Addendum

No. 1

Description: Revise front line beverage casework to accept cart. Separate eyewash from handsink per Code review comments.

Project Title Sheetz C-Store
Sawyer Road
Cameron, NC

A800

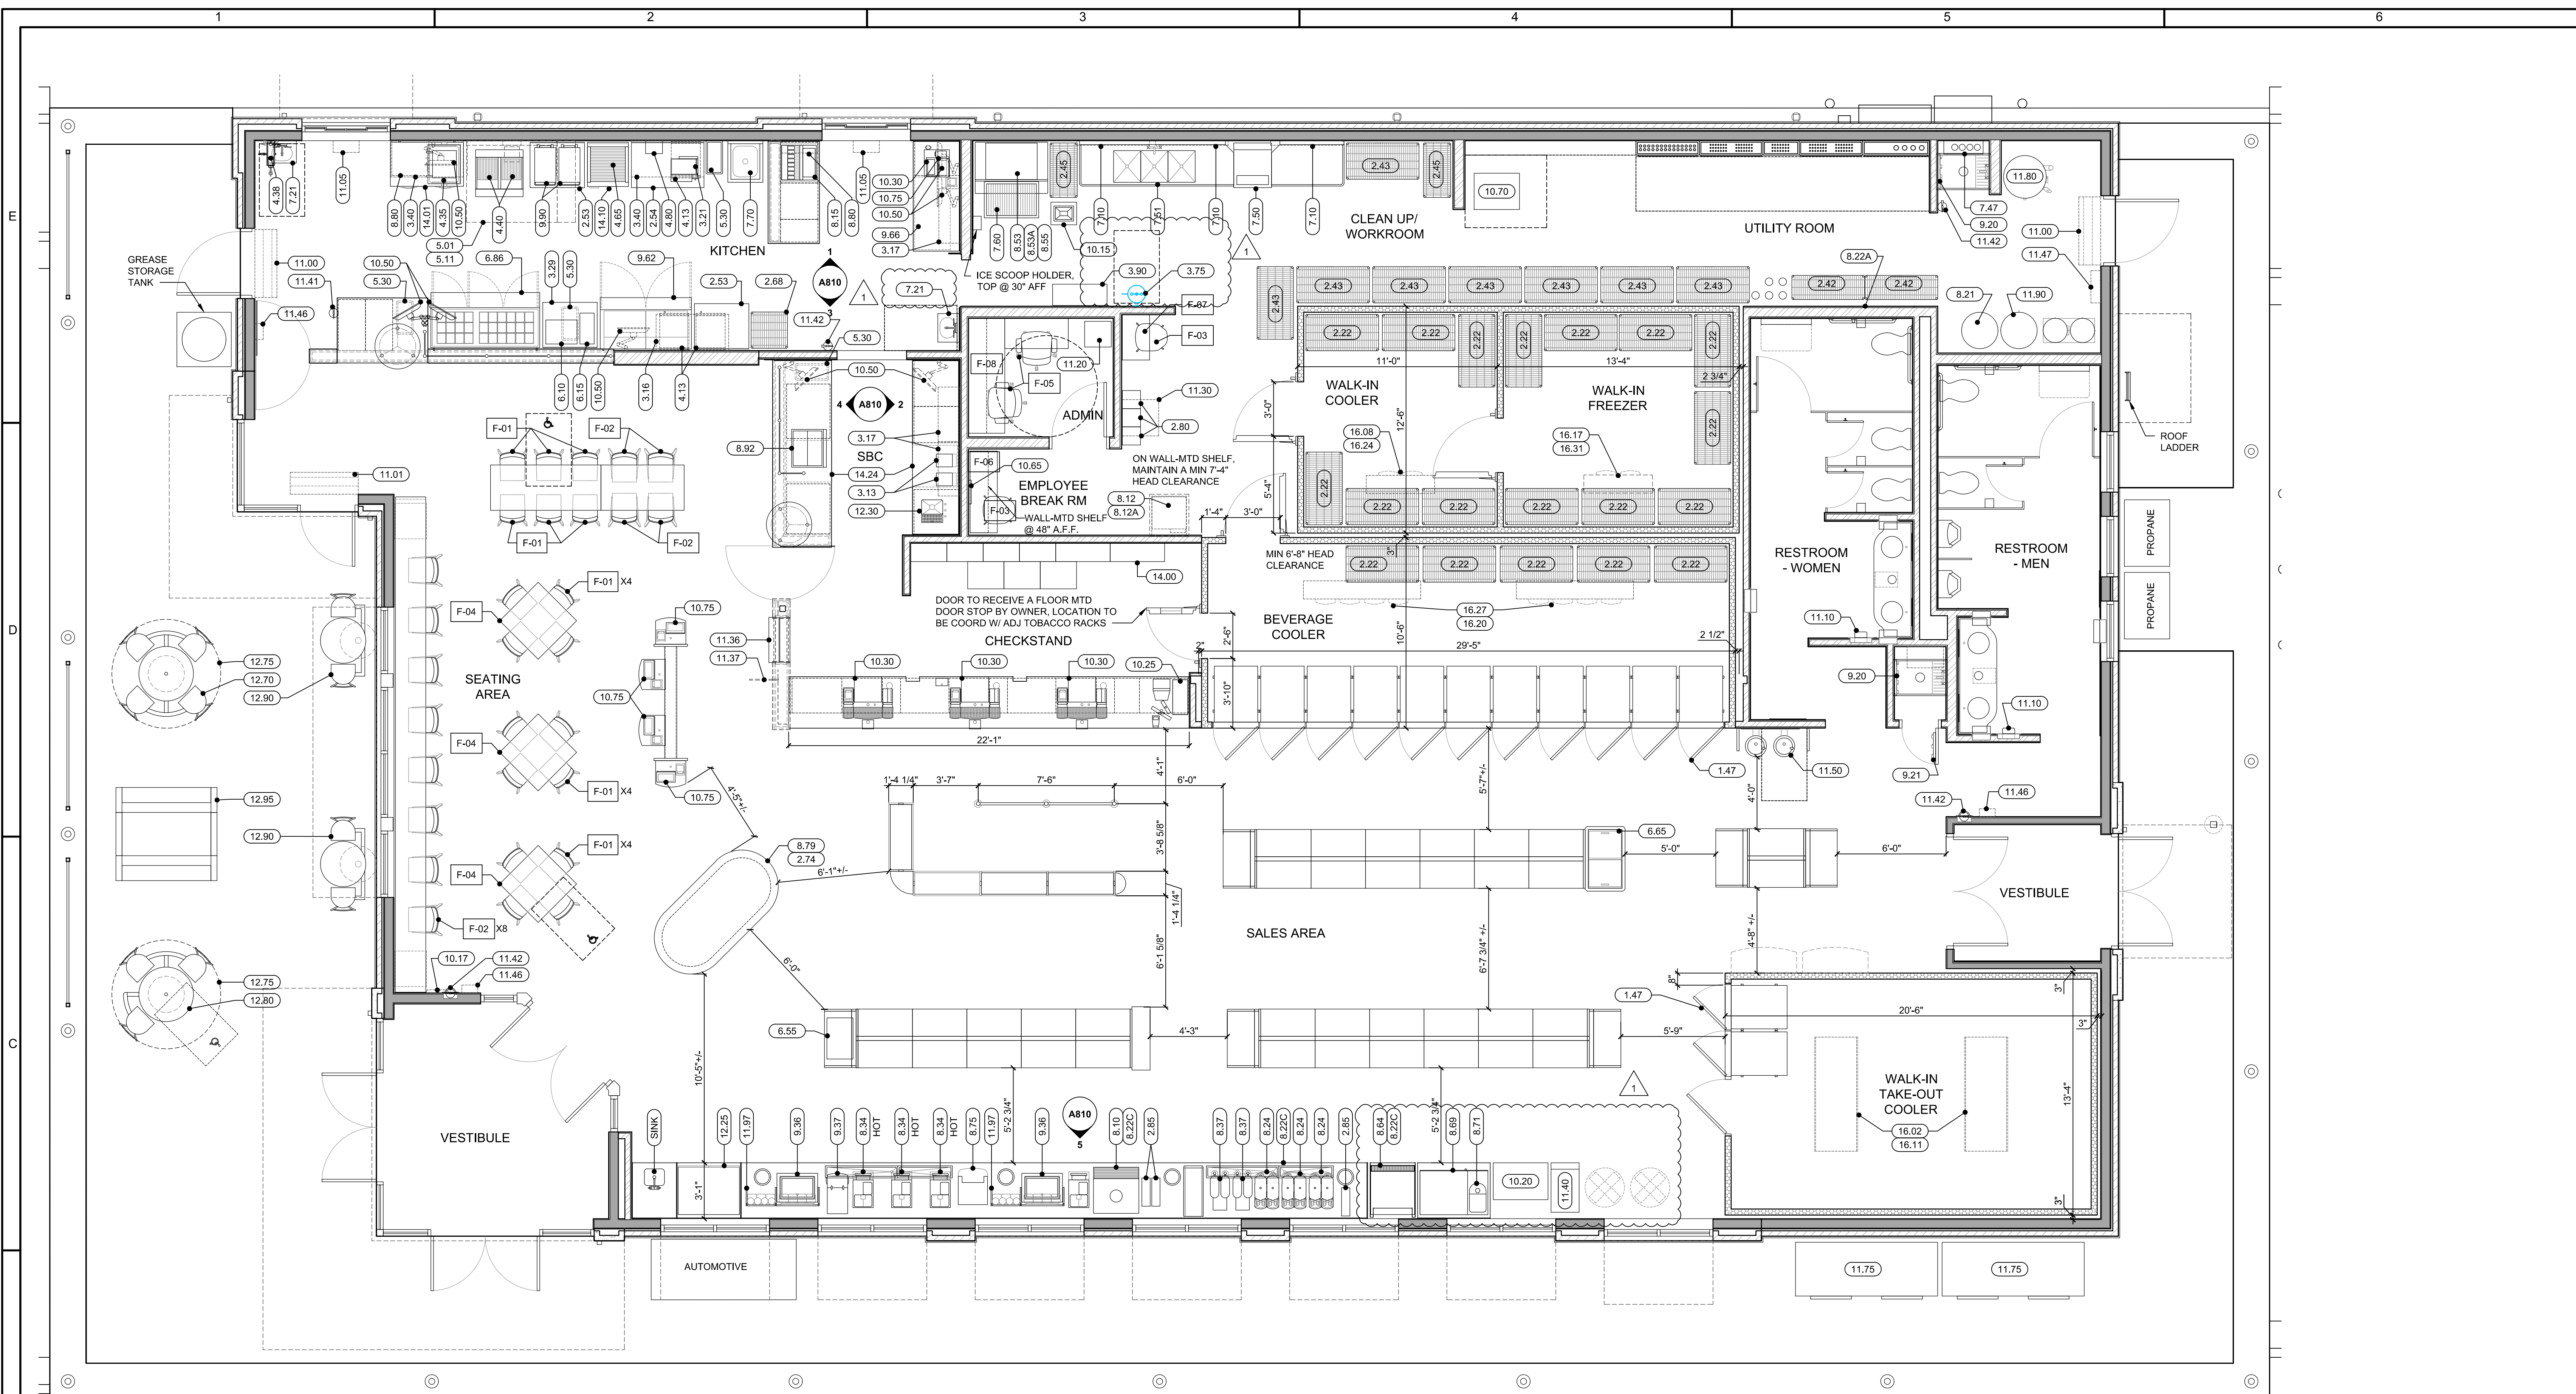
- Item 1: *A800 - EQUIPMENT PLAN- Revised beverage bar countertop. Separated eye wash from sink.*
- Item 2: *A810 - EQUIPMENT ELEVATIONS & DETAILS- Revised beverage bar elevation.*
- Item 3: *A900 - CASEWORK PLANS, ELEVATIONS & DETAILS- Added access panel note to detail 4.*
- Item 4: *A920 - CASEWORK PLANS, ELEVATIONS & DETAILS- Revised beverage bar countertop.*
